I have received the updated foundation drawing documents from our engineer and have attached them for the City's review and processing. A description of the changes is provided below. Please add the new drawings to our application for the building permit (Application 201602886) and please let us know when we can expect completion of the process.

Revised Drawings:

Drawing 520-37 General Arrangement (updated to revision 4)

**FOUNDATION DETAILS FOR 33KV. BUS STRUCTURE SUBSTATIONS GENERAL**

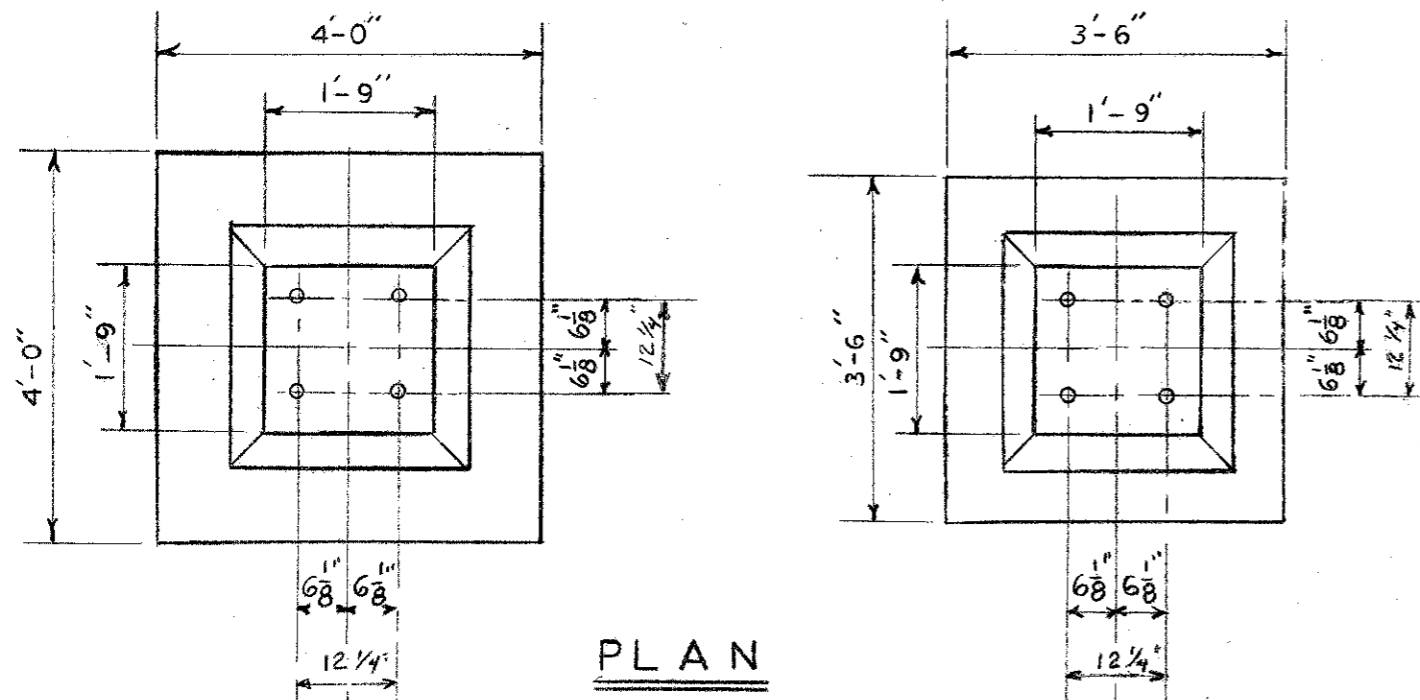
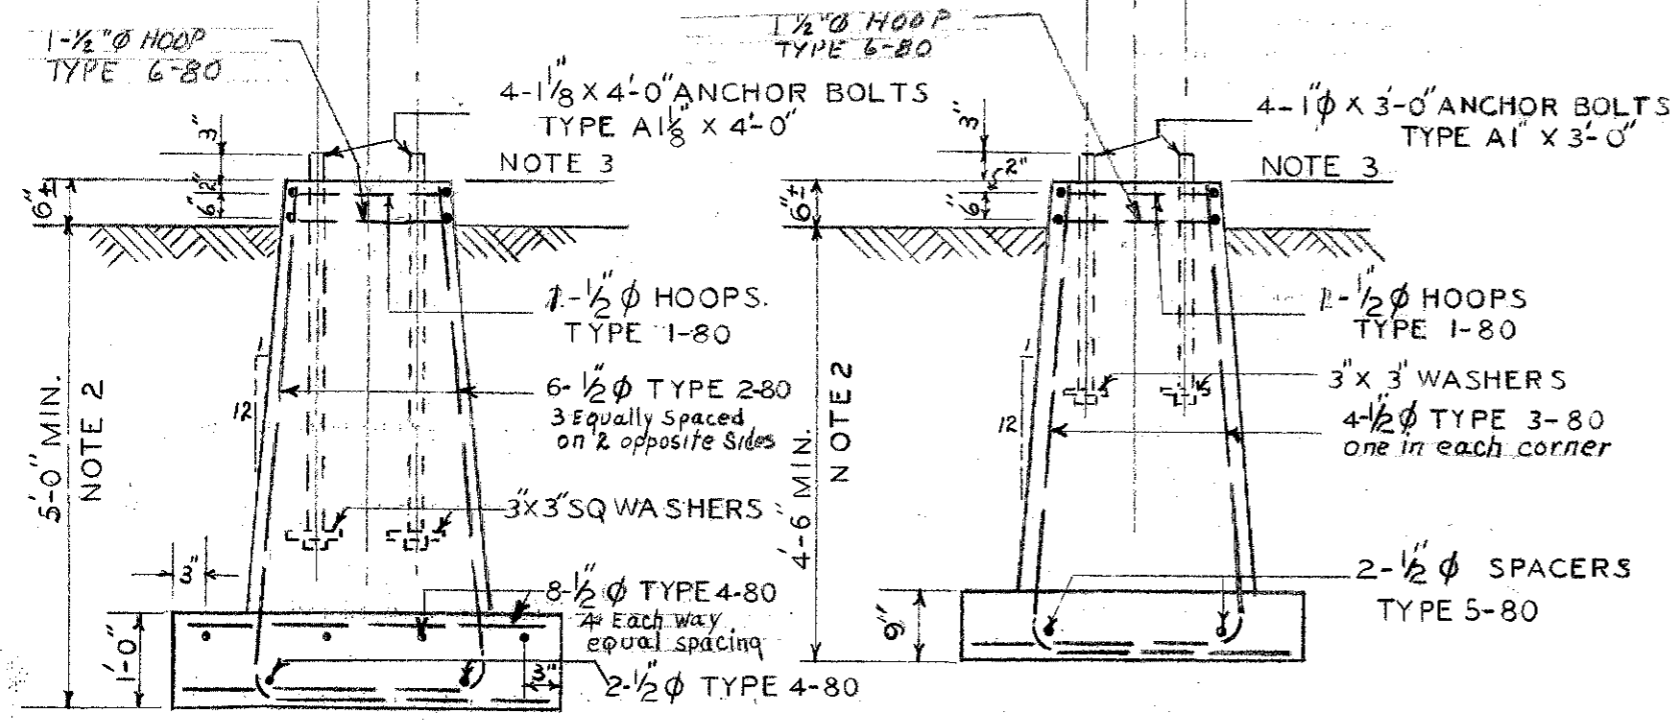
- Please note that the foundation detail drawings referenced in the foundation schedule were updated for foundation "A" and foundation "B".
- Foundation "A" now references drawing 520-03-17 (pier detail) and will replace drawing 520-80 figure 1.
- Foundation "B" now references drawing 520-03-18 (pier detail) and will replace drawing 520-80 figure 2.
- Drawing notes 5 & 6 were added
